Subject: RE: Planning Consultation on: A/124/19/RES

Engineers Comments Regarding Surface Water Drainage

APPLICATION NO: A/124/19/RES

Site Address: Merry England Nursery Dappers Lane Angmering BN16 4EN

CLIENT: GD CONCEPTS LIMITED	
DESIGNER: AINARA GOIKETXEA	
PROJECT: MERRY ENGLAND NURSERY, DAPPERS LANE, ANGMERING	
TITLE: BLOCK PLAN	
SCALE: AS INDICATED @ A1	DATE: 05.09.19
PURPOSE OF DRAWING: PLANNING	
DRAWING: PROJECT REF - DRG NO. (REVISION) 1920-PL-101-

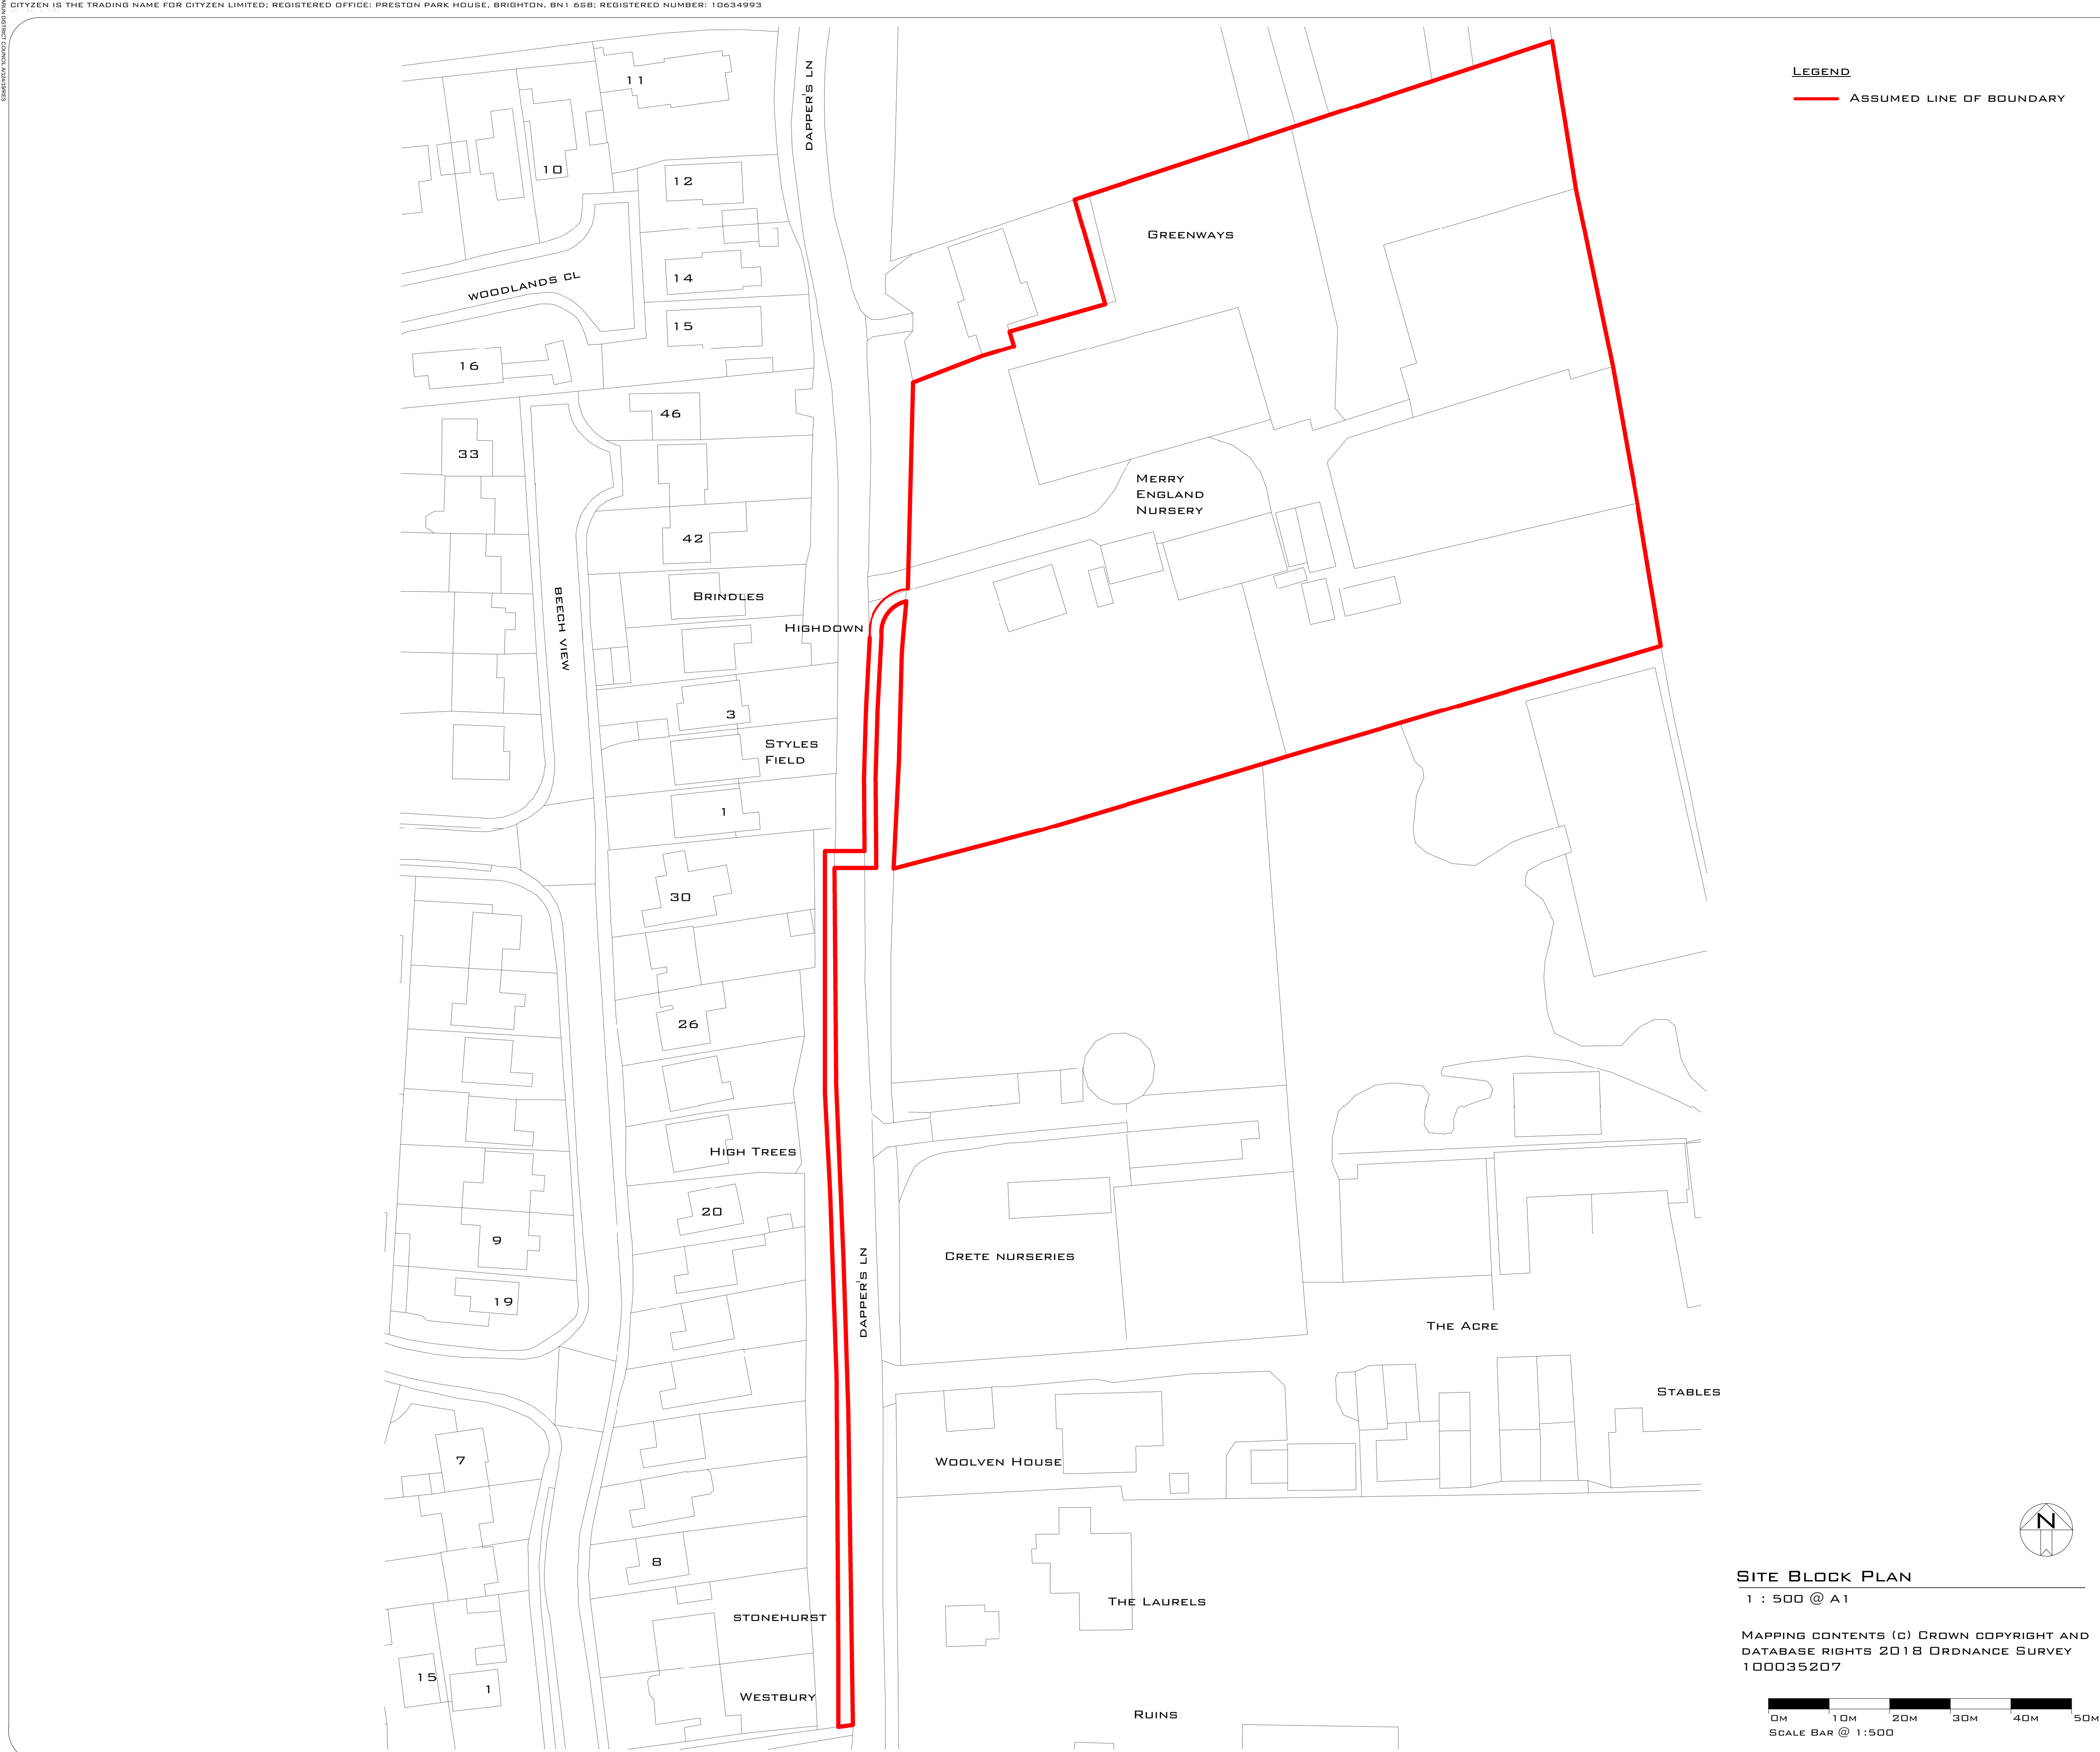
No layout plan has been provided as part of this application. Without this it is not possible to state if drainage will be unduly prejudiced by the proposed layout. **Please can details of the proposed layout and drainage strategy be provided prior to determination.**

Surface water drainage must be considered at the earliest opportunity and form part of the layout development process. The proposed layout should take consideration of the natural falls of the site and the location of watercourses to ensure that a gravity drainage solution can be achieved and sufficient easement to the watercourse is provided.
